Application No: R/90/22/HH
Site Address: Kingfishers 10 Fosters Close Rustington BN16 2TL
Description of works: Single storey side garage extension, front porch extension, hip to gable loft conversion including the installation of front dormers and rooflights and alterations to fenestration/openings.

Thank you for your internet representation made on 10th May 2022 which has been recorded as an objection with the comments as follows:

PROPOSED NORTH ELEVATION 1:100

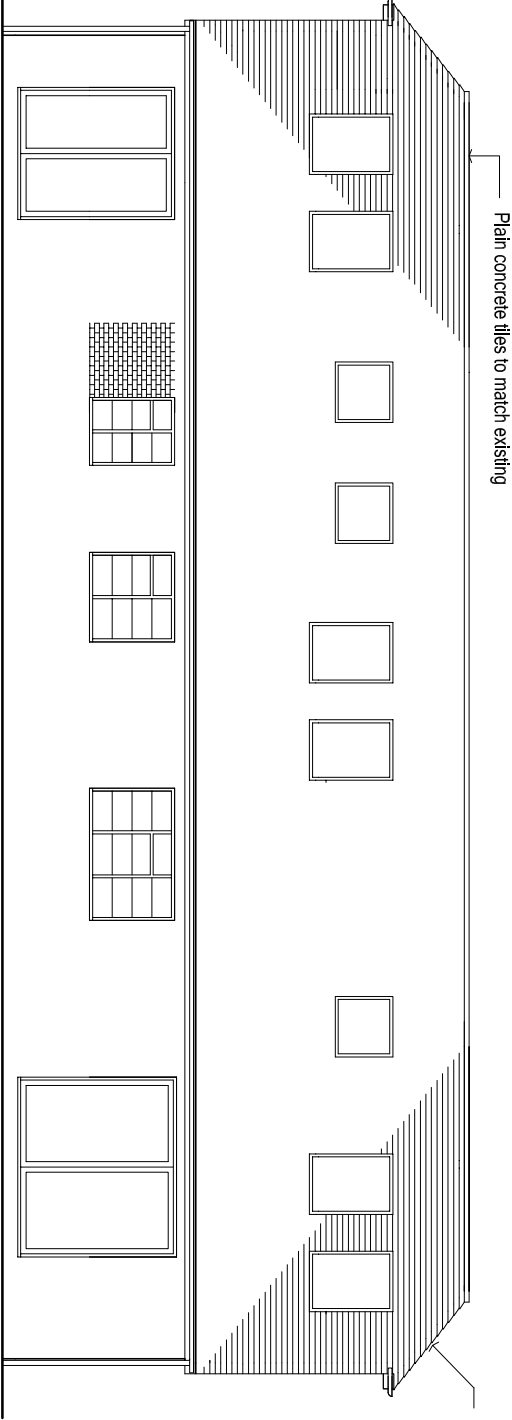
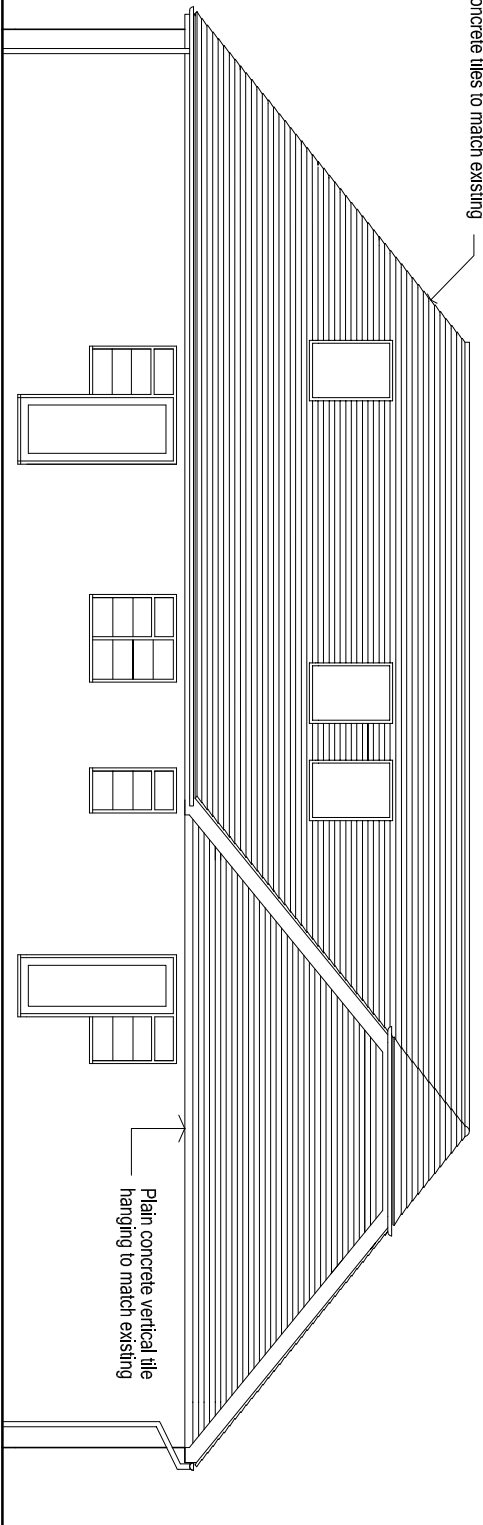
I am strongly against this planning application. My house, 1 West Mead, sits directly behind the north elevation of 10 Fosters Close. The 9 windows in the north elevation will look directly into my bedrooms and bathrooms windows, which are all south elevation. Neither of us will have any privacy at all, both will be able to see directly into each other's bedrooms and bathrooms.

This is accentuated even more so, by 10 Fosters being built only a few meters away from its boundary on the north side. Meaning ALL 9 north elevation windows are only a few meters away, from the boundary fence, completely overlooking my garden and as said into my bedroom and bathroom windows.

I will be going from having no windows looking directly into my house and garden to 9, ALL looking directly into my bathrooms, bedrooms and garden.
